Town and Country Planning Act 1990 (as amended)
Application for Non-Material Amendments to Planning Approval: LU/206/21/RES
Phase 5 Hampton Park, Littlehampton, BN17 7PP

This letter accompanies an application seeking approval for a number of Non-Material Amendments ("NMA") to Reserved Matters Approval LU/206/21/RES. The amendments relate primarily to the relocation of the northern footpath adjacent to the Black Ditch water meadow embankment, together with a limited number of boundary treatment and landscaping changes.

LA.PH5.5.
NMA_2

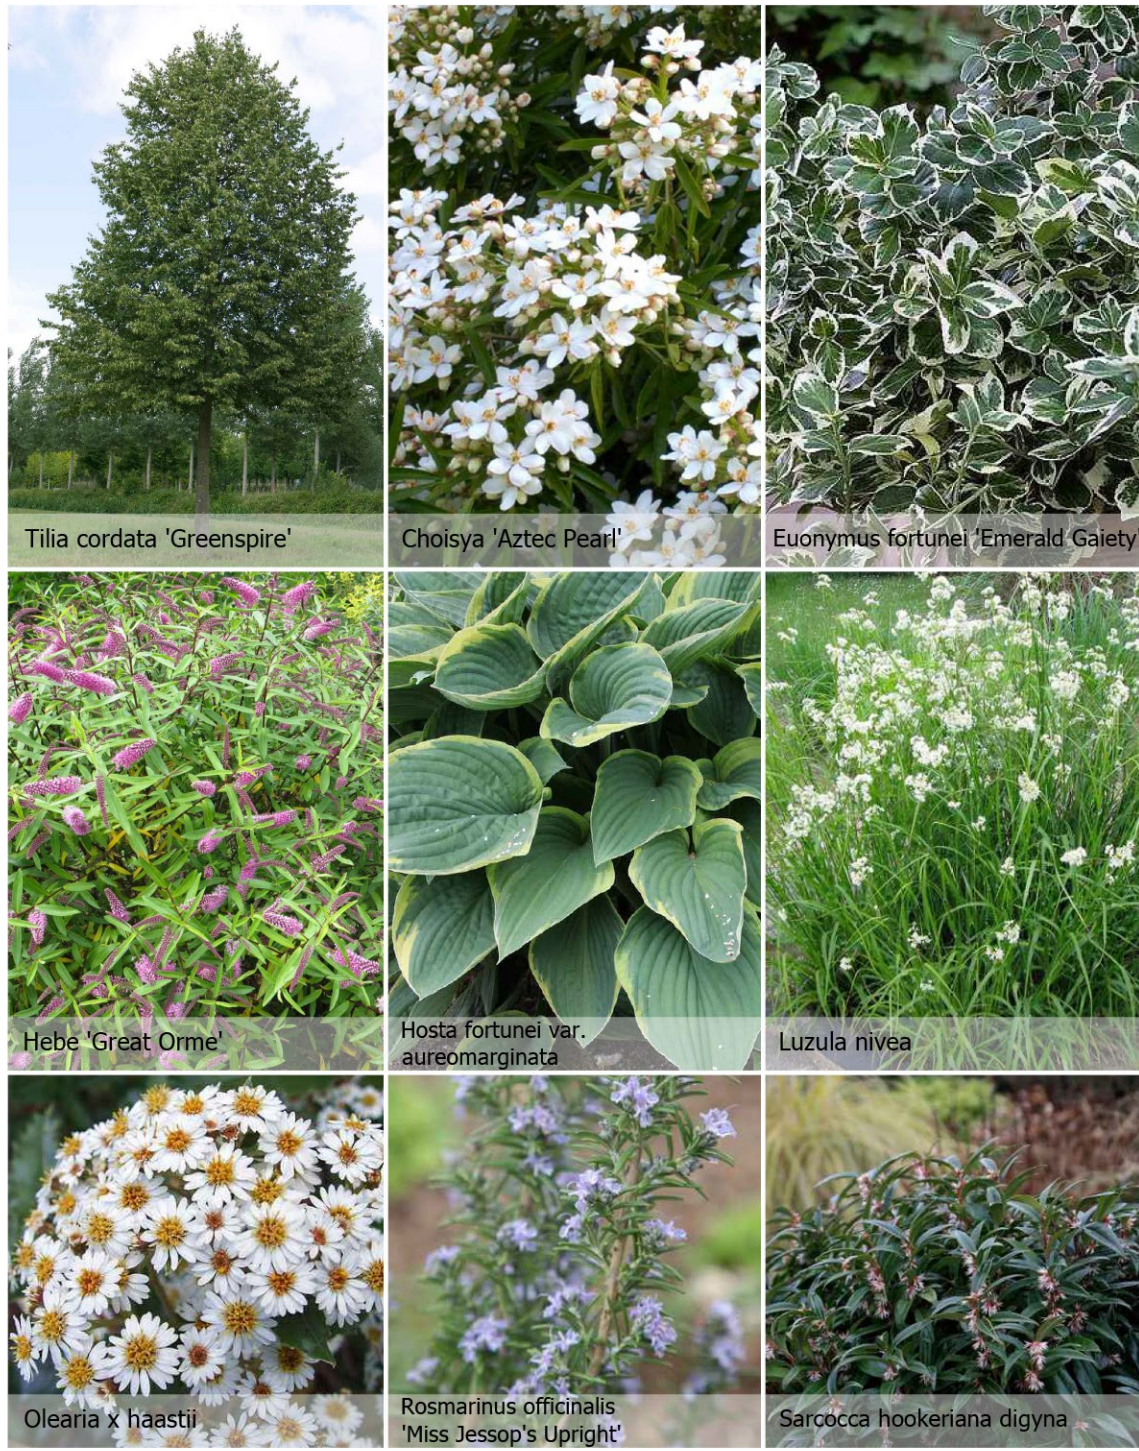
The approved scheme provided for a footpath along the crest of the Black Ditch embankment, which forms the northern boundary of the residential development. However, during the detailed design and implementation process it has become necessary to relocate the footpath to the toe of the embankment owing to ground stabilisation constraints. The revised alignment mirrors that proposed within the adjacent Phase 6a Reserved Matters application and will facilitate a continuous and seamless pedestrian route through this part of the development.

- cycle / footpath to side of plots 152 – 162 replaced with tarmac
- Development platform reinforced by the use of banking (1:3 slope) as an effective engineering solution with the cycle / footpath adjusted to be at the base of banks to ensure positive connectivity.
